Our Ref: LU/337/19/DOC

**Application for approval of details reserved by conditions imposed on planning permission
LU/205/16/PL relating to conditions 6 & 12 - soakaway design alternative & soakaway design
calculations**

CM Wood Body Repair Centre Linden Park Littlehampton BN17 7BJ

Arun District Council have decided to **REFUSE details reserved by condition for the following reasons:**

DRAWING TITLE
SOAKAWAY DESIGN ALTERNATIVE TO PERMEABLE PAVED INFILTRATION SYSTEM

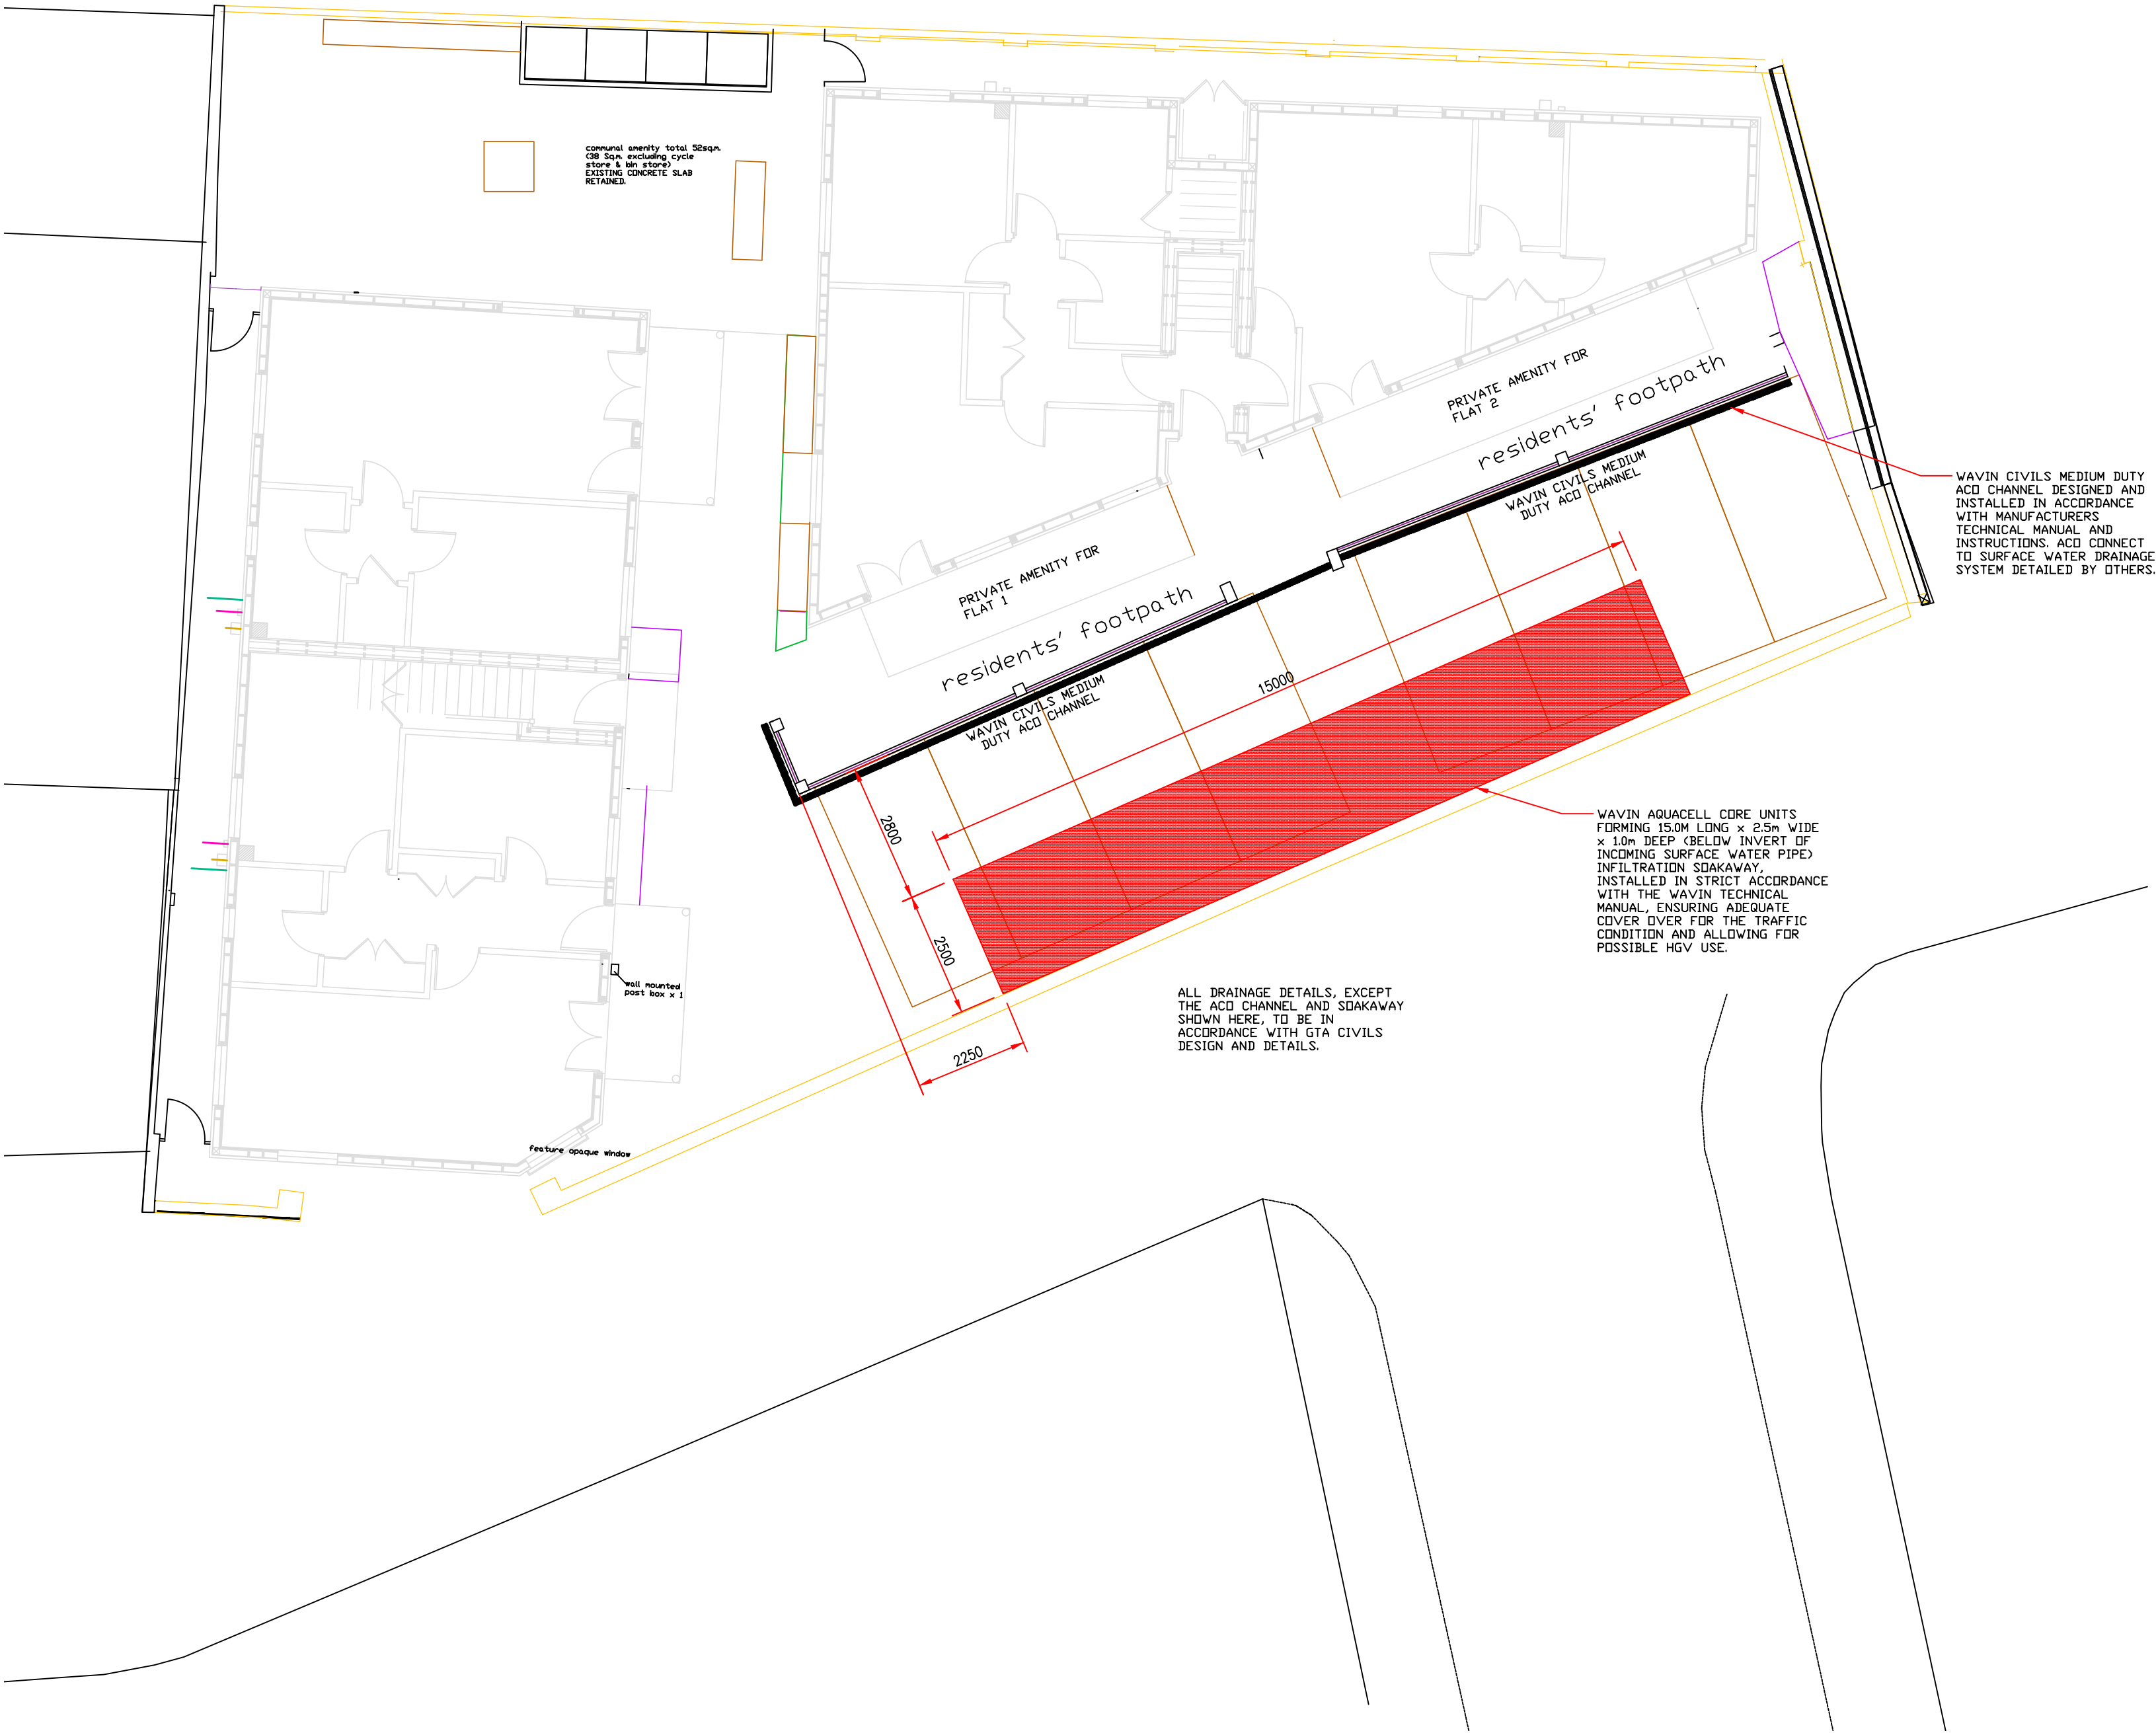
1. The proposed soakaway is 1.25m deep, with no information given as to the cover depth, although MH1 invert level is 0.5m bgl so it is safe to assume that the base of the proposed soakaway will be at

least 1.7m bgl. It seems that the testing does not reflect the depth of the infiltration structure. Please recomplete infiltration testing in January-March in accordance with BRE365 to the appropriate depth of the proposed soakaway. This should be used to calculate a more accurate infiltration rate to inform the design.

2. Drawing details for the soakaway and ACO channel require cross section and the addition of the invert levels of the pipes entering the soakaway and the soakaway invert level and/or the level of the top of the soakaway.

3. Please include details of pipe diameters and materials..

4. Please add 40% allowance for climate change. This is still set to 30% however there is more than enough capacity to compensate (on basis of infiltration rate which will change).
